FAO: Planning Department,  
Welwyn Hatfield Borough Council

Ref: 6/2018/0136/LB  
Date: 22/10/2019

## HISTORIC BUILDINGS AND CONSERVATION ADVICE

**RE: *Oshwal Centre, Coopers Lane, Northaw, Potters Bar, EN6 4DG***

DRAWING TITLE
WINDOWS 7-8-9

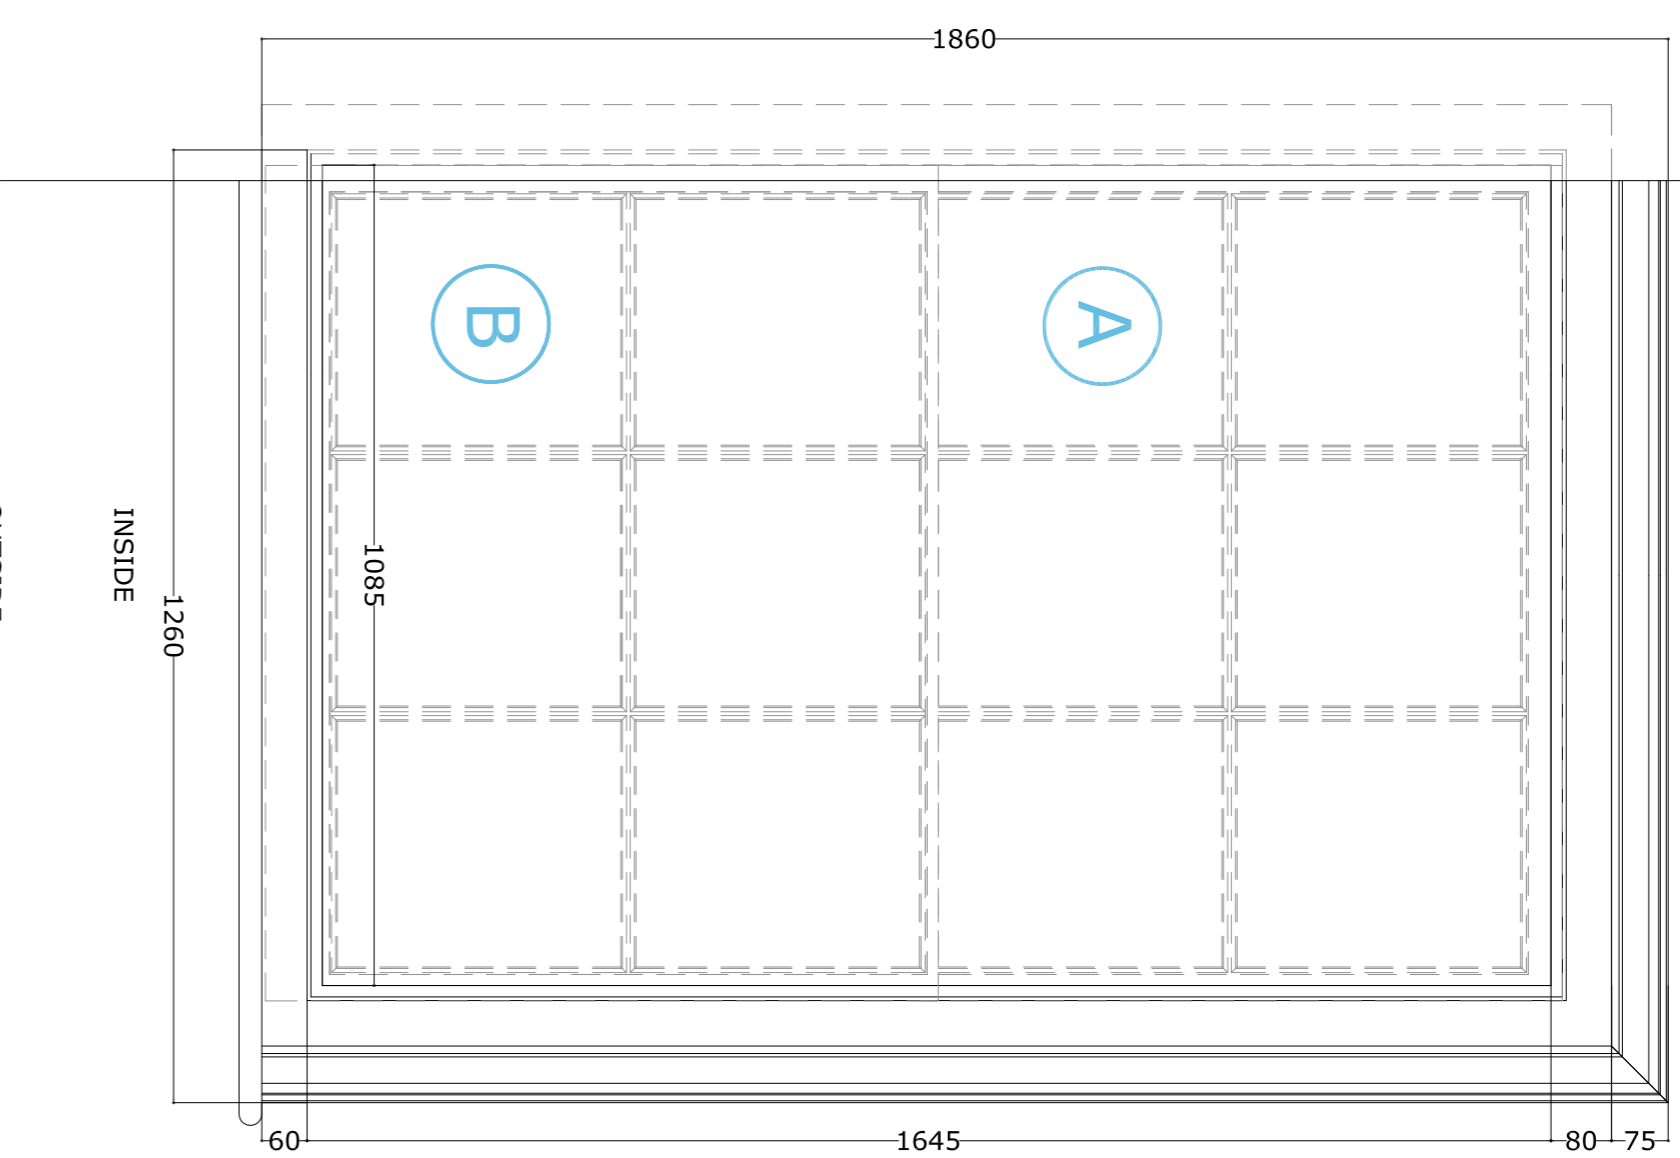
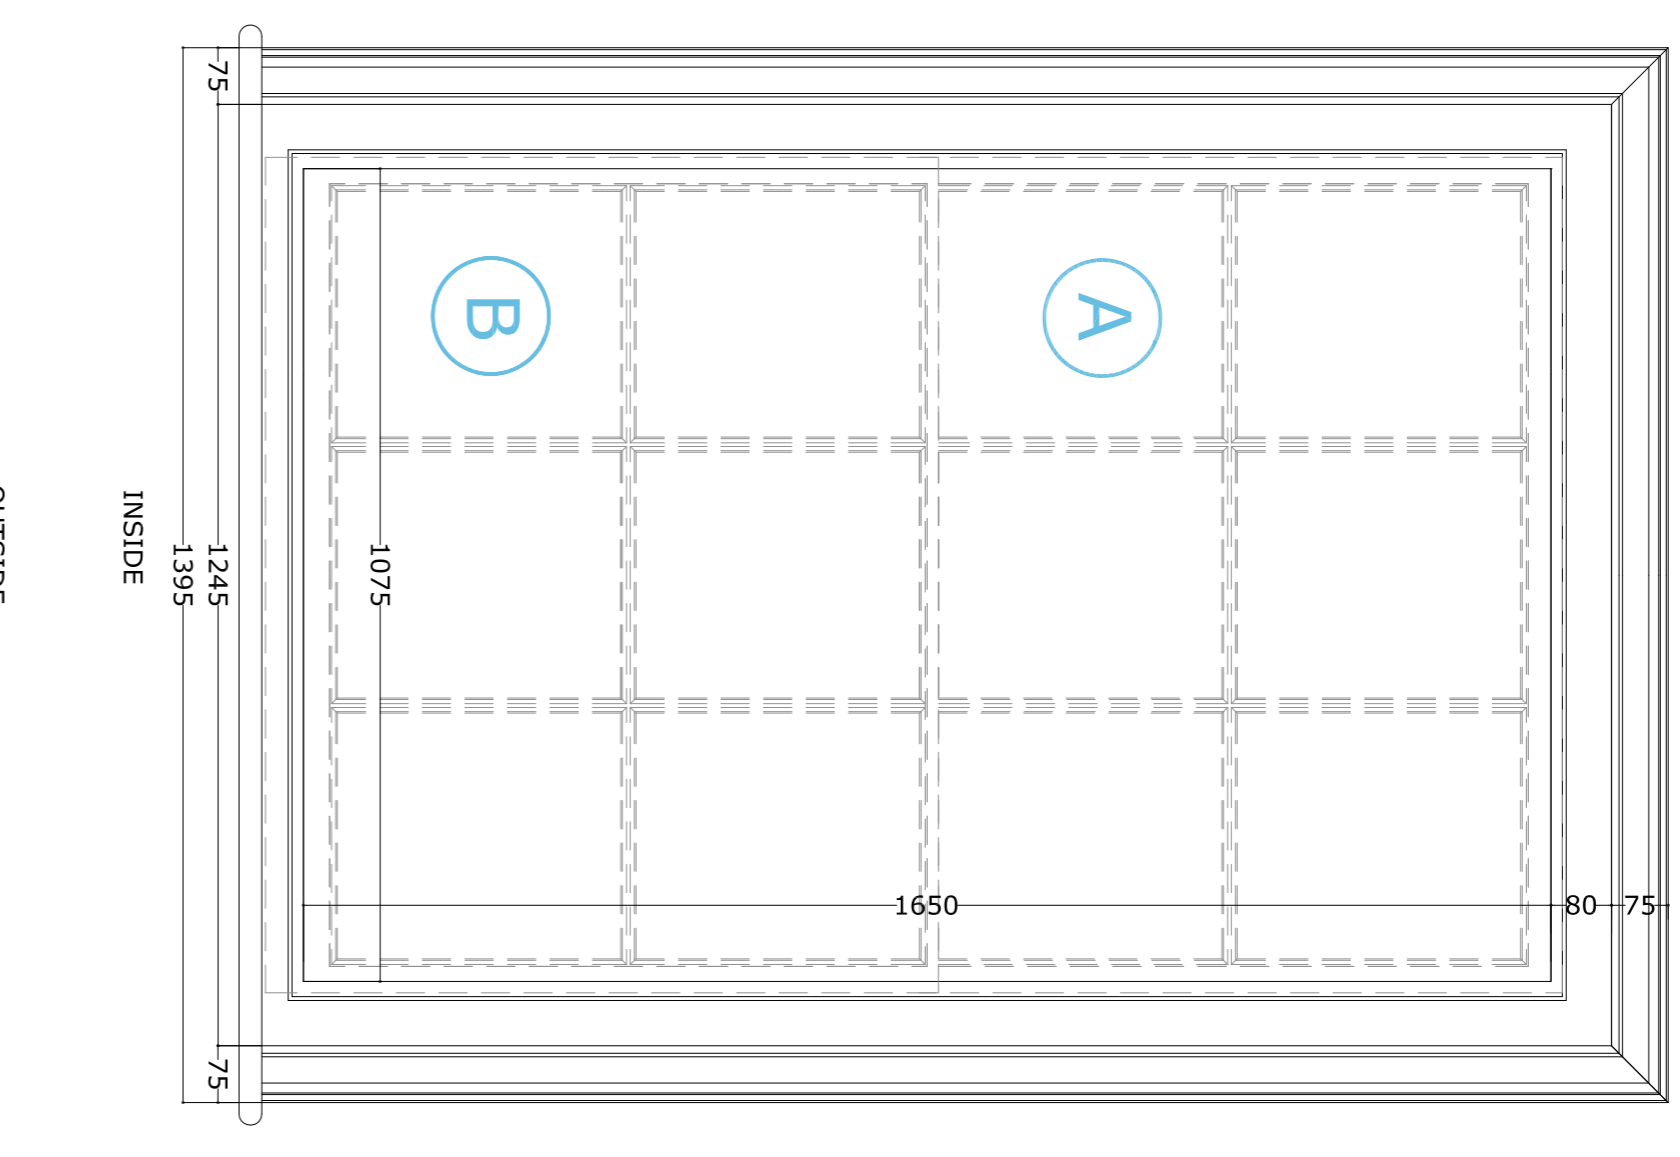
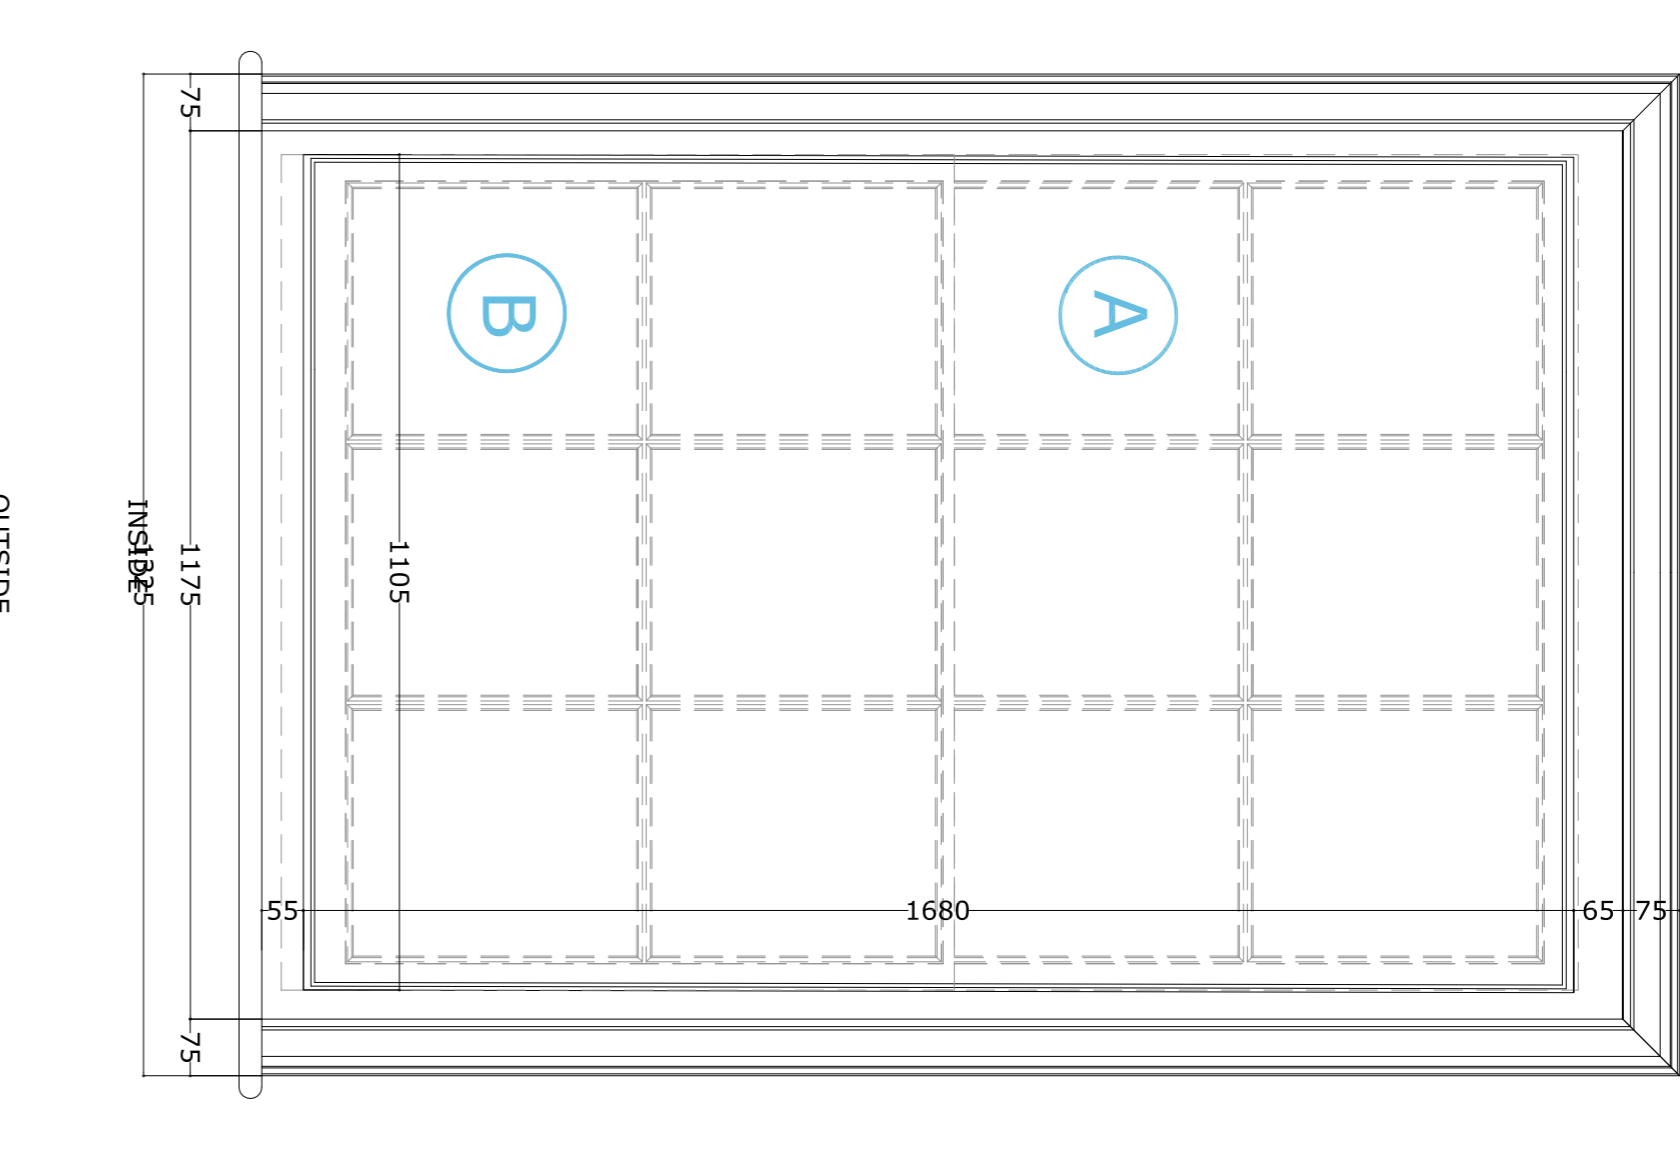
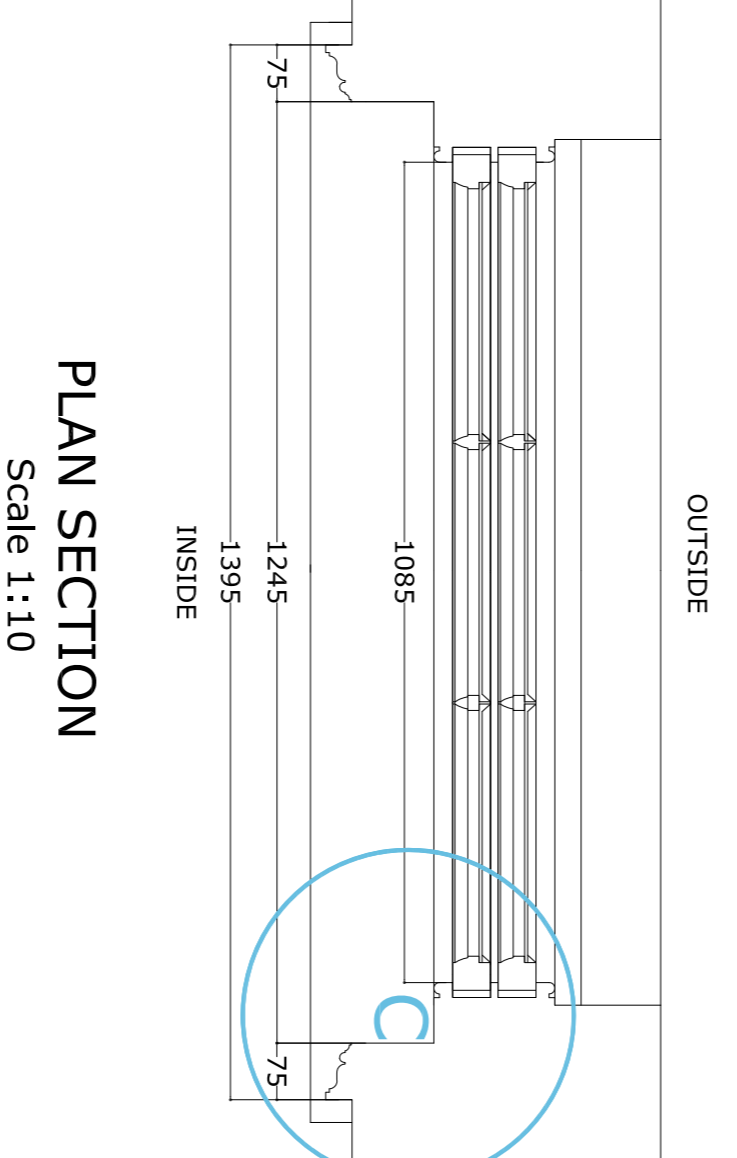
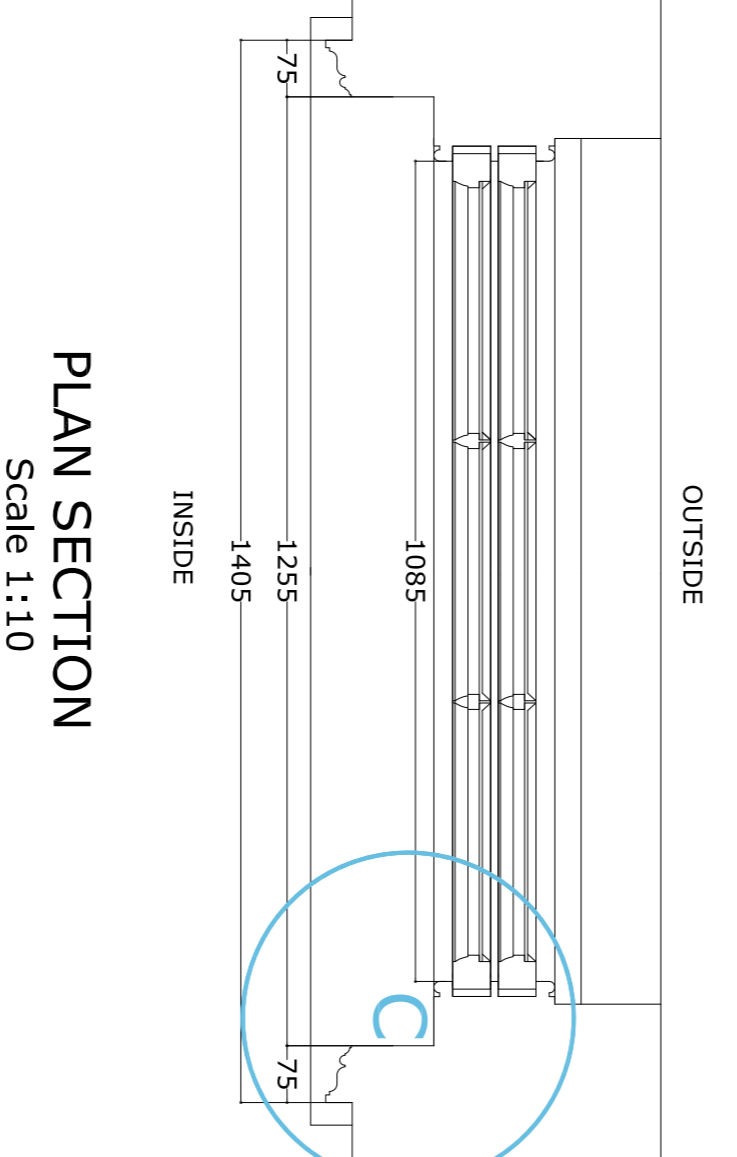
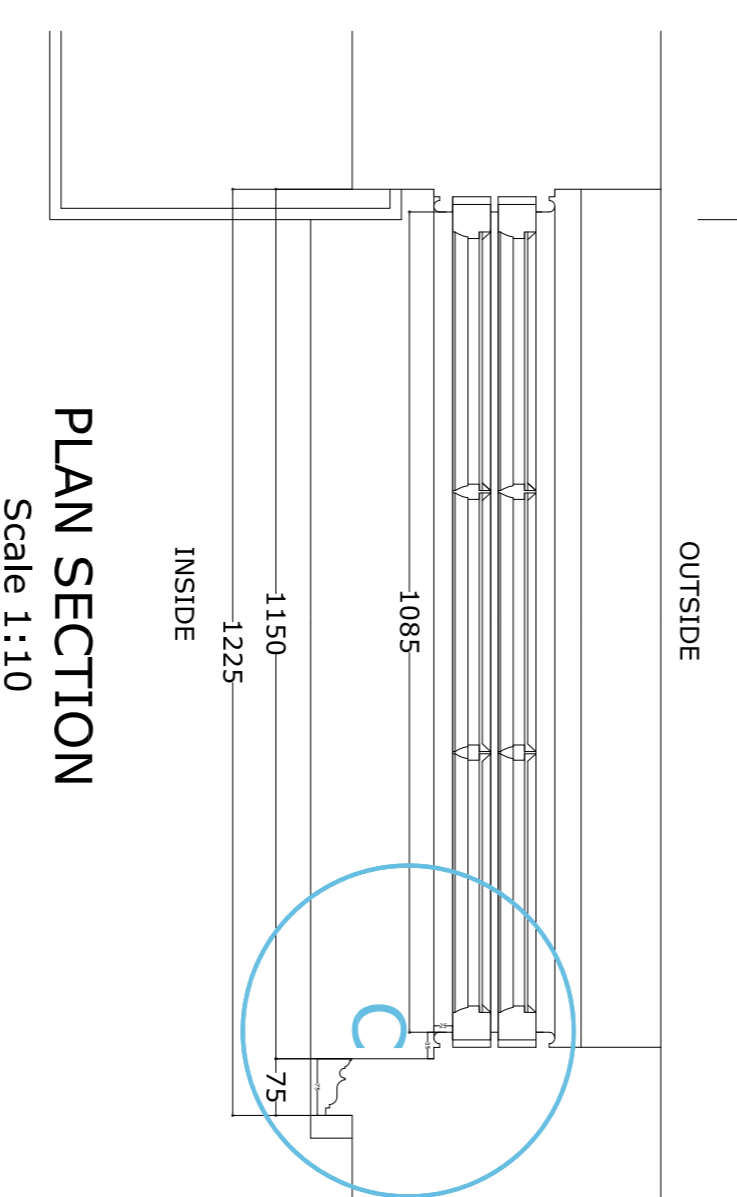
Window nos. 4, 5, 6, 7, 8, 9, 27, 28, 29, 30, 31, 32, 49, 50, 51, 52, 60, 61, 62 (paragraph no. 2.12 of *Heritage Statement*) appear to relate to a later phase of building work dating to the late 19<sup>th</sup> century. They are still of interest as historic elements of the building and their difference to the windows above is important in denoting the historic evolution of the building. Whilst not part of the primary phase, they are still of historic interest. It is recommended that these windows are also repaired and

only replaced if beyond viable repair. The replacements should be on a like-for-like basis including single glazing. Double glazing will not be acceptable.
